From: Sue Howell <Sue.Howell@arun.gov.uk>
Sent: 21 September 2020 12:54
To: Planning.Responses <Planning.Responses@arun.gov.uk>
Cc: Amy Myer <Amy.Myer@arun.gov.uk>; James Cross <James.Cross@arun.gov.uk>
Subject: RE: Planning Consultation on: BE/81/20/OUT

From: Arun District Council Leisure & Greenspace

Application ref: BE/81/20/OUT

Location: Chalcroft Nursery Chalcroft Lane Bersted PO21 5TS

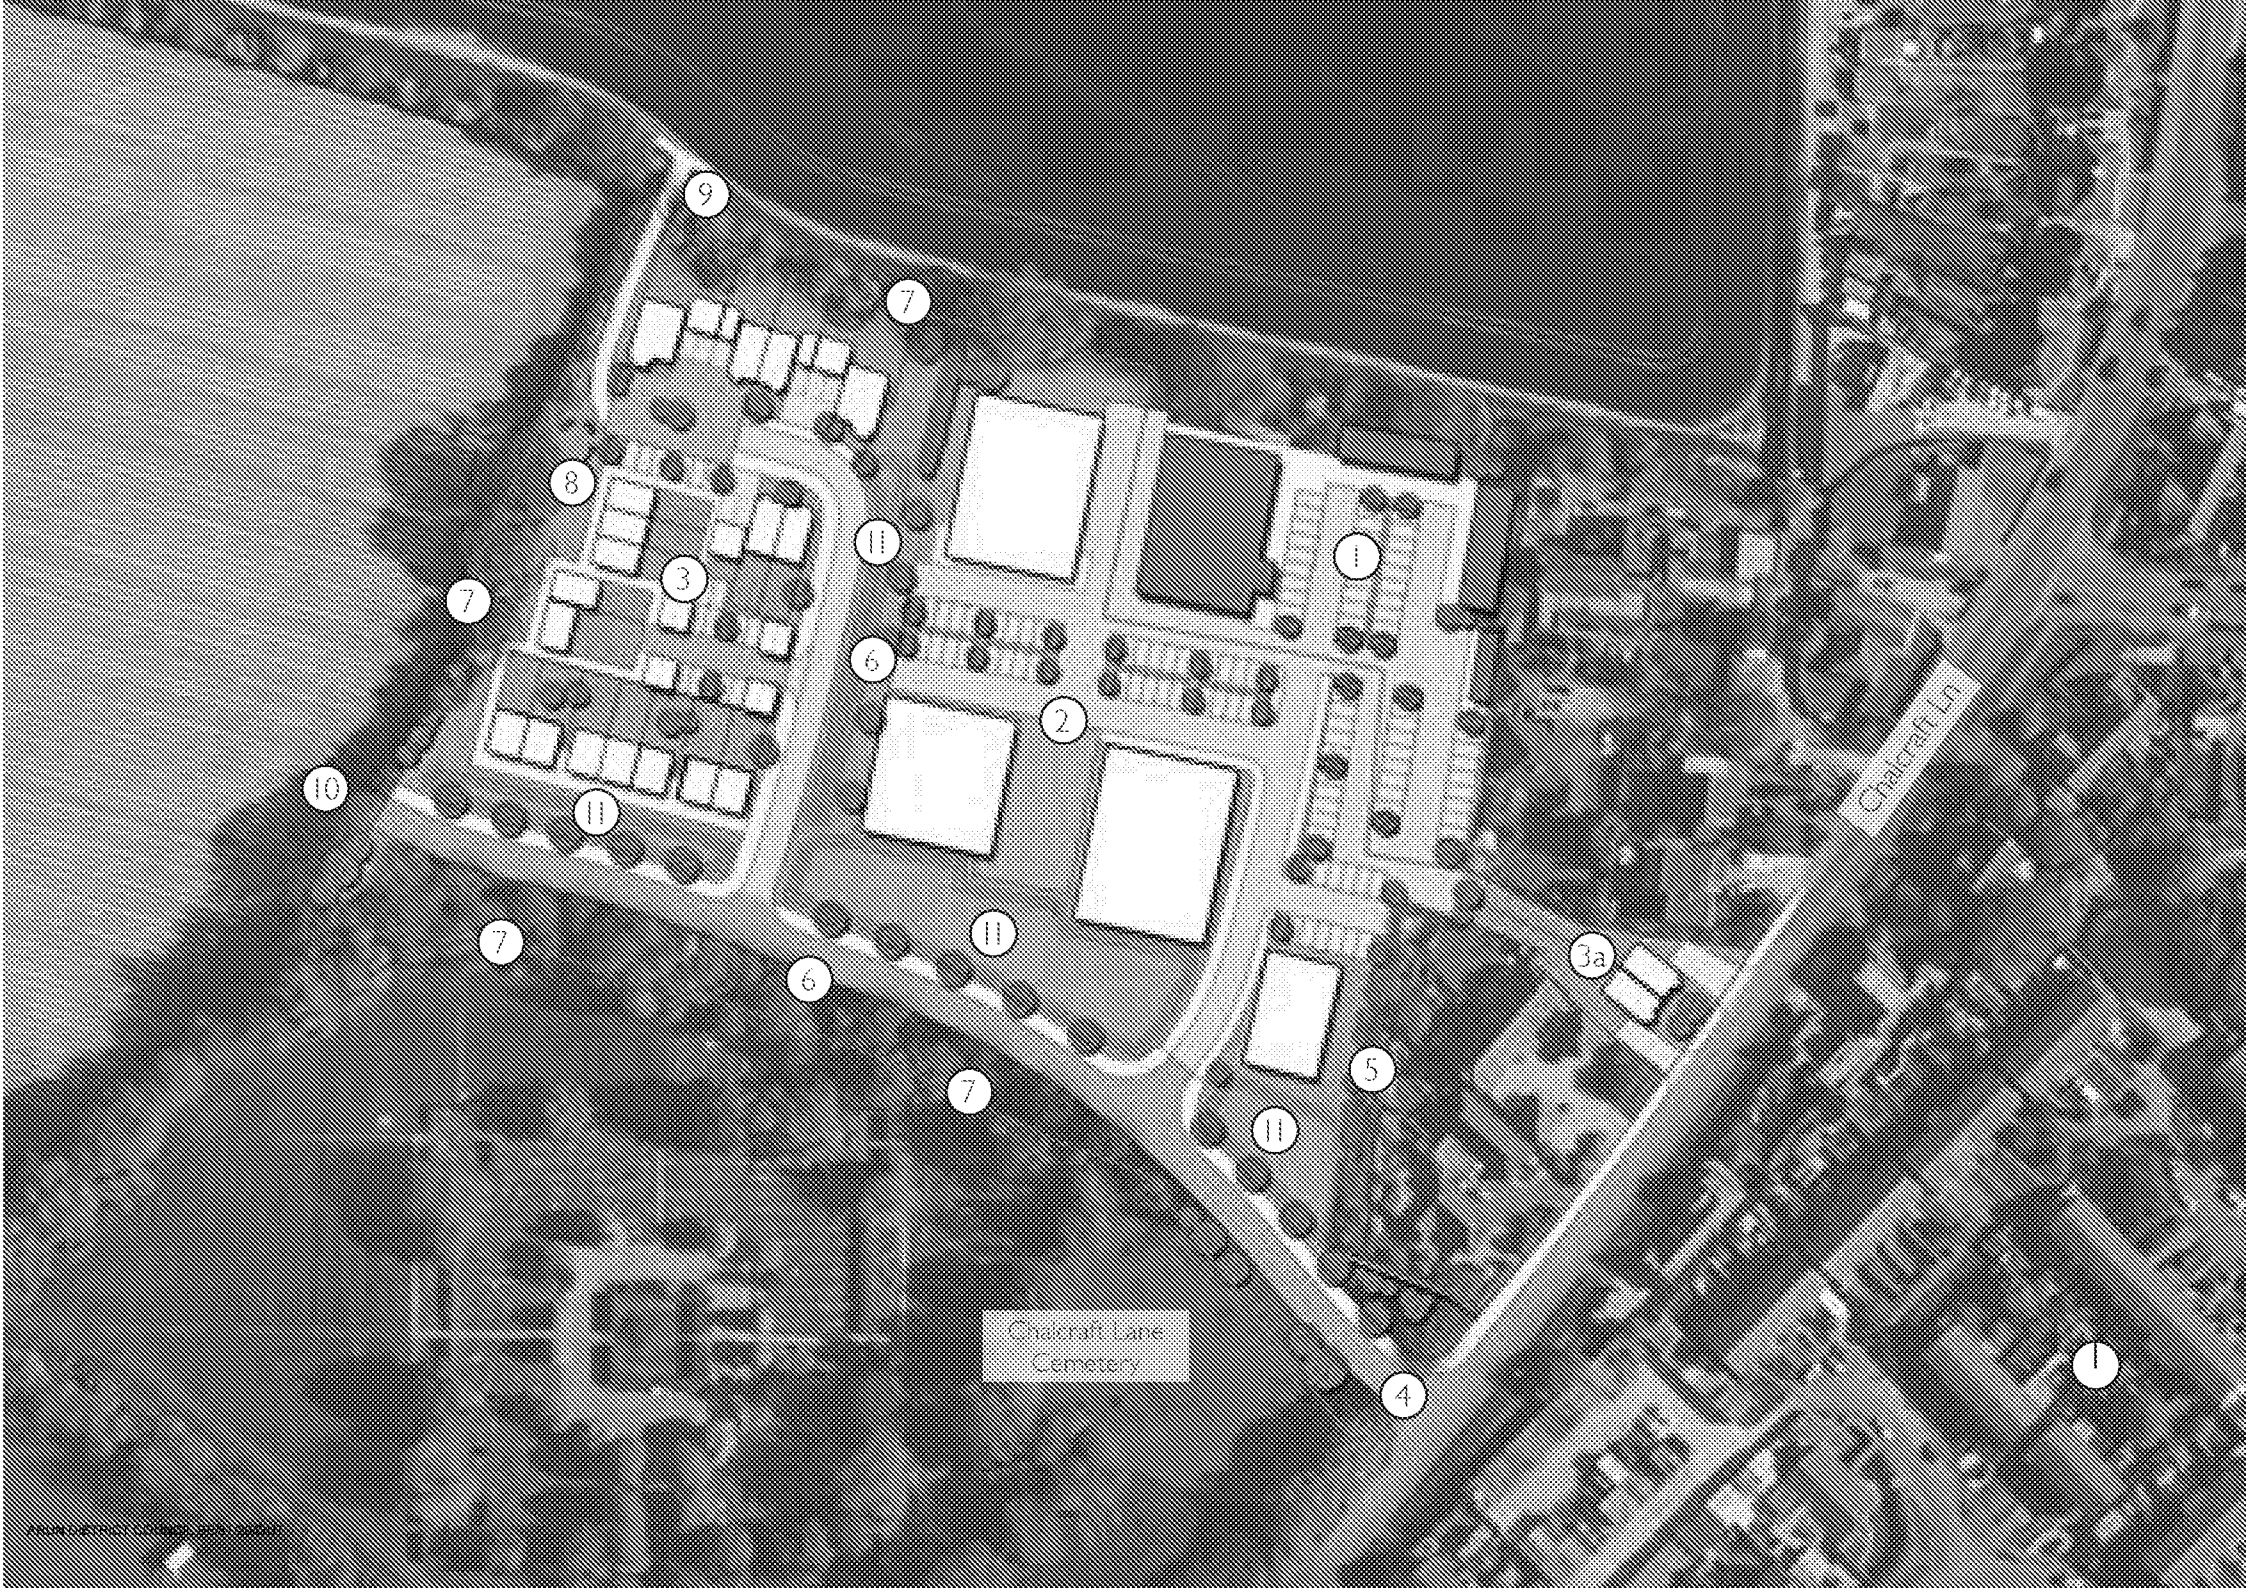
The Illustrative Masterplan dwg 01304 SK 002 has shown the layout of the commercial element and the location of the dwellings. An element of POS will be required with this portion which does appear to have been provided, we would require further detail of this re quantum and content.

The POS has indicated a LAP which would be required, this needs to form a natural element of play including elements such as landform, boulders, logs seat and bin.

for the planting of trees, shrubs and grass verge areas. A reinforced boundary planting strategy will need to be employed in this area and replicated throughout the housing area in interests of visual amenity. It would seem a shame that the indicated commercial building 270m² sits so close to this main entrance road into this site, consideration should be given to the siting of this away from this entrance road and allowing a greater open green area to this location. Indicative tree planting is shown on the Illustrative Masterplan, which will need to be shown in greater detail. Detailed planting plans will need to be provided in plan form detailing species choice, actual quantities, planting densities and size at time of planting, to show the extent and also of screening to be provided to the existing dwellings which neighbour this proposal.
